Subject: FW: Planning Consultation on Y/88/19/DOC

Subject: RE: Planning Consultation on Y/88/19/DOC

Engineers Comments Regarding Surface Water Drainage

P.T. PLANNERS LTD
North Barn Flansham
Drainage Strategy Plan
Dwg 11095-01 03-10-19

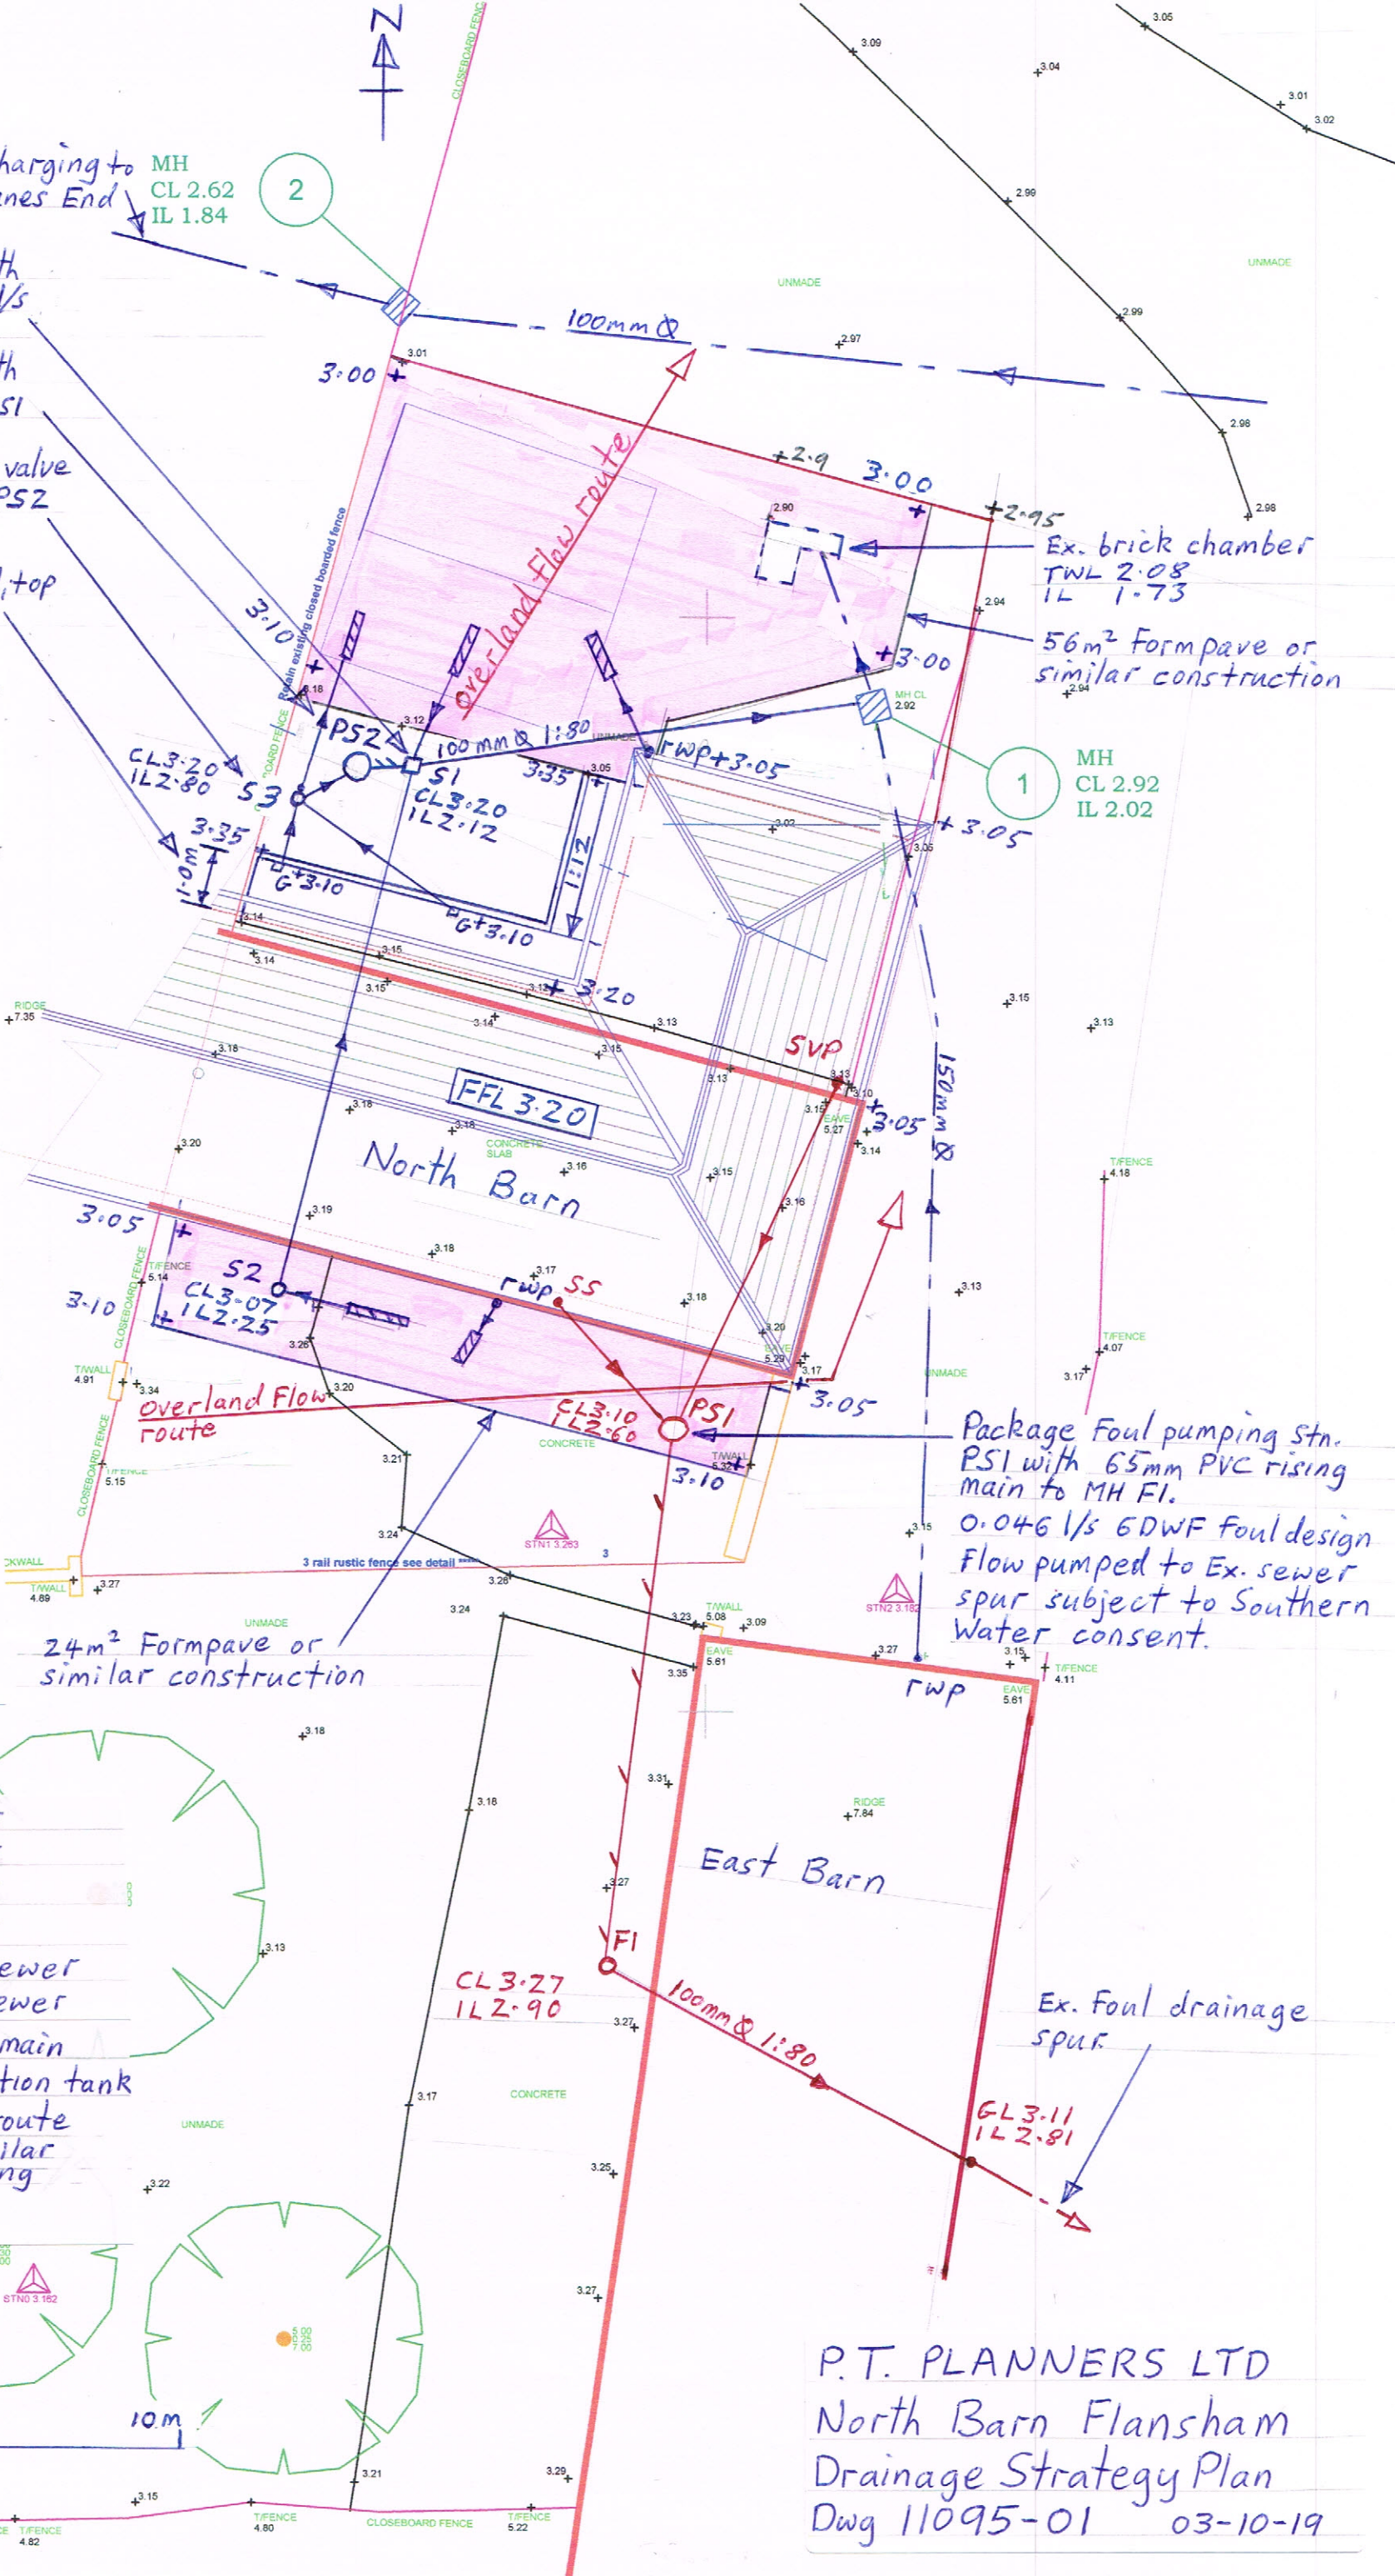
No infiltration testing or groundwater monitoring has been completed. The reason given for this is evidence of clay in the BGS borehole and trial holes. In this case the BGS borehole and trial holes are not an adequate substitution for infiltration testing. Please complete a soakaway test in accordance with BRE 365 to 0.5m depth to assess the viability of shallow soakaways.

The condition clearly states that; *"The design should follow the hierarchy of preference for different types of surface water drainage disposal systems as set out in Approved Document H of the Building Regulations, and the recommendations of the SuDS Manual produced by CIRIA."* Therefore Infiltration is prioritised above attenuation and restricted discharge to a watercourse.

We provide a Surface Water Drainage Proposals Checklist. Please complete this and submit it with your updated proposal on the basis of the test listed above. Within the checklist it is clearly stated what information is required in order to discharge the condition, including design details. I have attached a copy for your convenience, however one can also be found at <https://www.arun.gov.uk/download.cfm?doc=docm93ijjm4n14067.pdf&ver=14313>
